## RE SUBMISSION TO SYDNEY GATEWAY ROAD PROJECT SSI-9737

This submission has been prepared on behalf of Qantas Airways Limited including related bodies corporate of Qantas (**Qantas**) in relation to the State Significant Infrastructure Application (**SSIA**) and preliminary draft Major Development Plan (**MDP**) for the Sydney Gateway Road Project (**Gateway Project**) submitted by Roads and Maritime Services (**RMS**) now known as Transport for NSW (**TfNSW**) and Sydney Airport Corporation Limited (**SACL**).

Figure 8.10 **Location of intrusions into the prescribed airspace at Sydney Airport**

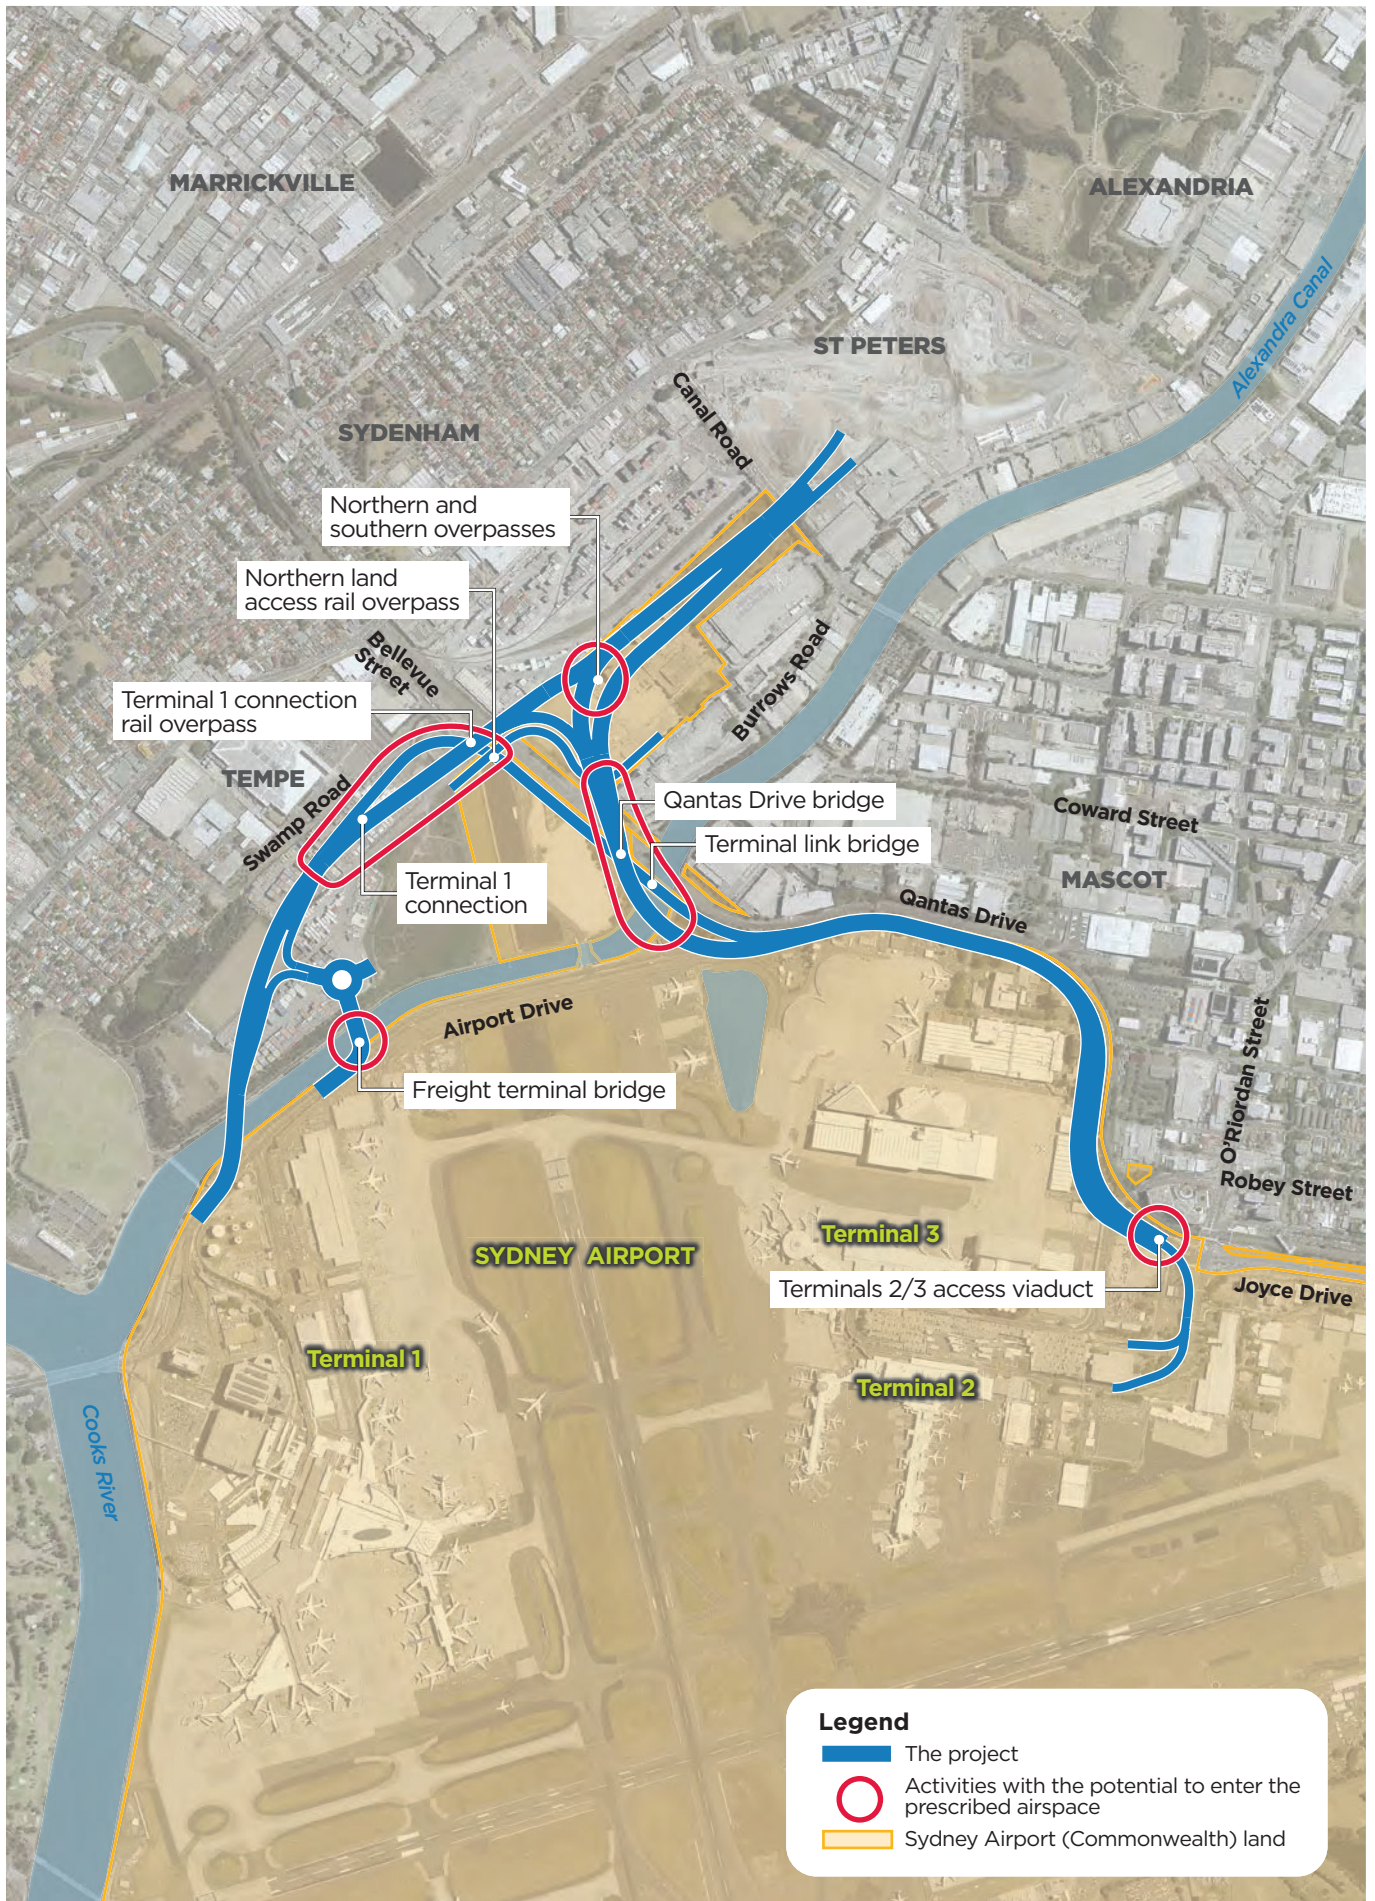
- a) Impacts on the Obstacle Limitation Space (**OLS**) are addressed in Section 11.3.1, which states:  
*“Construction activities involving the use of tall plant and equipment (such as piling rigs used to construct piles and cranes used to lift bridge segments) would likely result in temporary intrusions into the OLS. Where possible, construction would be undertaken in a manner that avoids such intrusions from occurring; however, some intrusions would be unavoidable. ...It is proposed to undertake such works during Sydney Airport’s curfew (ie between 23:00 and 06:00), staged over a number of nights. While some flights still occur during the curfew hours, there are significantly fewer flights. In addition, during these hours, flights typically arrive from*

Whilst the above assessment acknowledges that some flights occur during curfew hours, there is limited information to understand how the works will be managed to ensure there is no restriction to Qantas' permitted operations during the curfew including:

Qantas is seeking clarity on the impact to runway movements by the construction of the Gateway Project and if there will be any restrictions during curfew hours for the flying operations identified above. A communication protocol is required as a mitigation measure to ensure construction works do not prevent aircraft movements especially those that have been granted a dispensation during the curfew. We expect this matter will be assessed by CASA and request to be consulted during the process and informed of the outcome.

- b) Section 3.3.1 of TWP 3 – Airport Operations states that a *"3D model of the OLS and HIAL protected surfaces was received from Sydney Airport Corporation and was used to check against all permanent project infrastructure. The same surfaces were also used to identify locations where temporary intrusion by construction plant could occur."* We expect that CASA will wish to examine the model, as such, Qantas requests a copy of the 3D model be made publicly available to consider and verify the potential intrusions into the OLS.

- c) Whilst it is acknowledged that construction work affecting approaches to Runway 16R will be undertaken during the Airport's curfew, with cranes and other tall plant and equipment lowered during the day, Qantas is seeking to understand what contingencies will be in place in the event that a crane or other such plant and equipment becomes 'stuck' in the elevated position. Qantas experienced a situation of this nature earlier this year in San Francisco. This situation would not only prevent aircraft from using Runway 16R (Sydney's primary runway for large aircraft) but would also:

In order to limit any potential adverse impact on or limitation of Qantas's operations, Qantas recommends that the following contingency plan is required for the Gateway Project:

1. A pre-determined alternative aircraft landing zone (displaced threshold) for situations where the full length of runway is not available due to the Gateway project.
2. The ability to mark the temporary displaced threshold with 'v-bars' in accordance with MOS Part 139.
3. Provision of a temporary visual approach slope indicator (i.e. PAPI) to the displaced threshold.

Figure 11.2 Windshear assessment trigger areas for runways near project

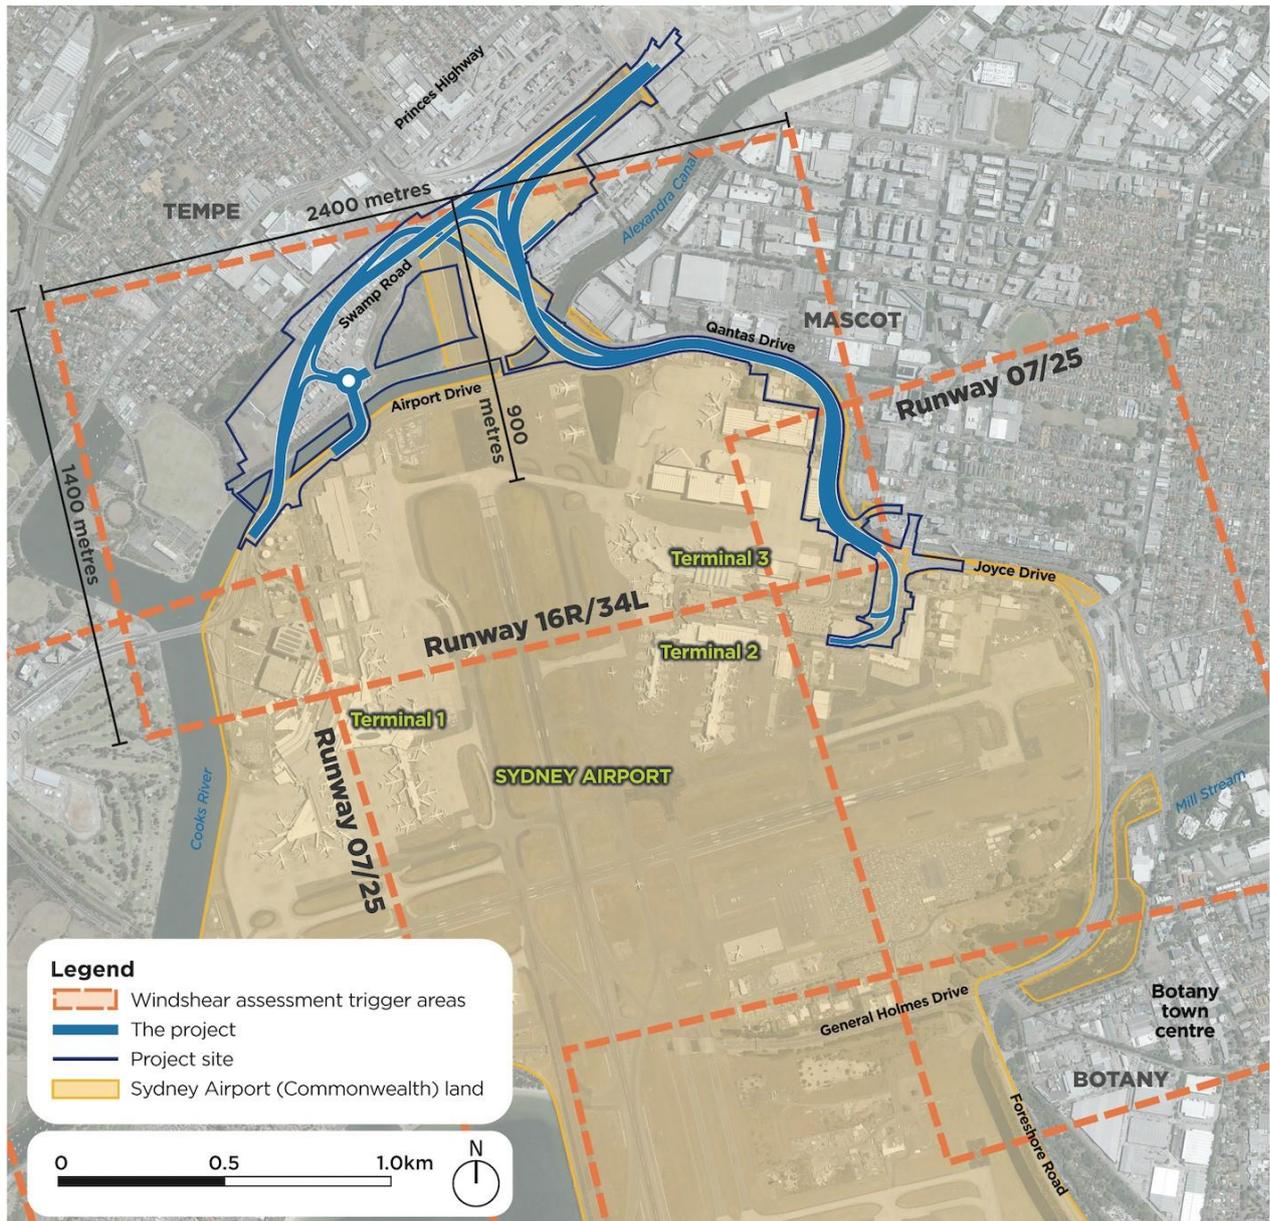
- a) Section 7.10 of the EIS indicates that the Gateway Project would involve the re-emplacement of a portion of the excavated waste material in the form of mounds, located as follows:
- One mound is proposed in the area bounded by the Terminal 1 connection, the freight terminal access and the western side of Alexandra Canal; and
  - Two options are being considered for the location of another mound – either north of the freight terminal access or west of the Terminal 1 connection.

- b) In relation to the effects of windshear and turbulence on aircraft as a result of the emplacement mounds, the following comments are made in relation to the assessment.

TWP3 Section 6.4.2 states *"The road infrastructure and final landforms (including the mounds) would be reviewed and refined during detailed design to (amongst other things):*

To be true to this principle, modelling of the mounds/roadway should be considered against a 'clean' environment with no shipping containers, not against the already less than ideal situation with stacked shipping containers located adjacent to the approach path.

As indicated in the Wind Tunnel Tests Report that accompanies TWP 3, operating requirements at the Airport limit a gust cross-wind component to 20kt before it is necessary to close a runway. Given that current aircraft have the capacity to operate at 40kt crosswinds, the design of the Gateway Project, including the emplacement mounds and roadway, must not restrict future potential operating capacities. It should be noted that proposals are currently being developed to increase the cross-wind tolerance above the 20kt value.

In addition to this, there are occasions where currently the crosswind component is higher than the 20 knots (**kt**) for both the main runway and the cross runway. This would occur when the wind direction was diagonal to the direction of both runways (around 211° True North) and based on capability of current aircraft (40kt for B738/B787) could land in windspeeds of up to 58kt. We are seeking clarification of whether these factors have been included in the assessment

- c) Qantas has commissioned its own assessment of wind directions, which has determined that wind directions in the vicinity of the Airport have changed in the past 12 months. It is requested that the Project Team review the modelling of turbulence and windshear based on the findings of Qantas' assessment.
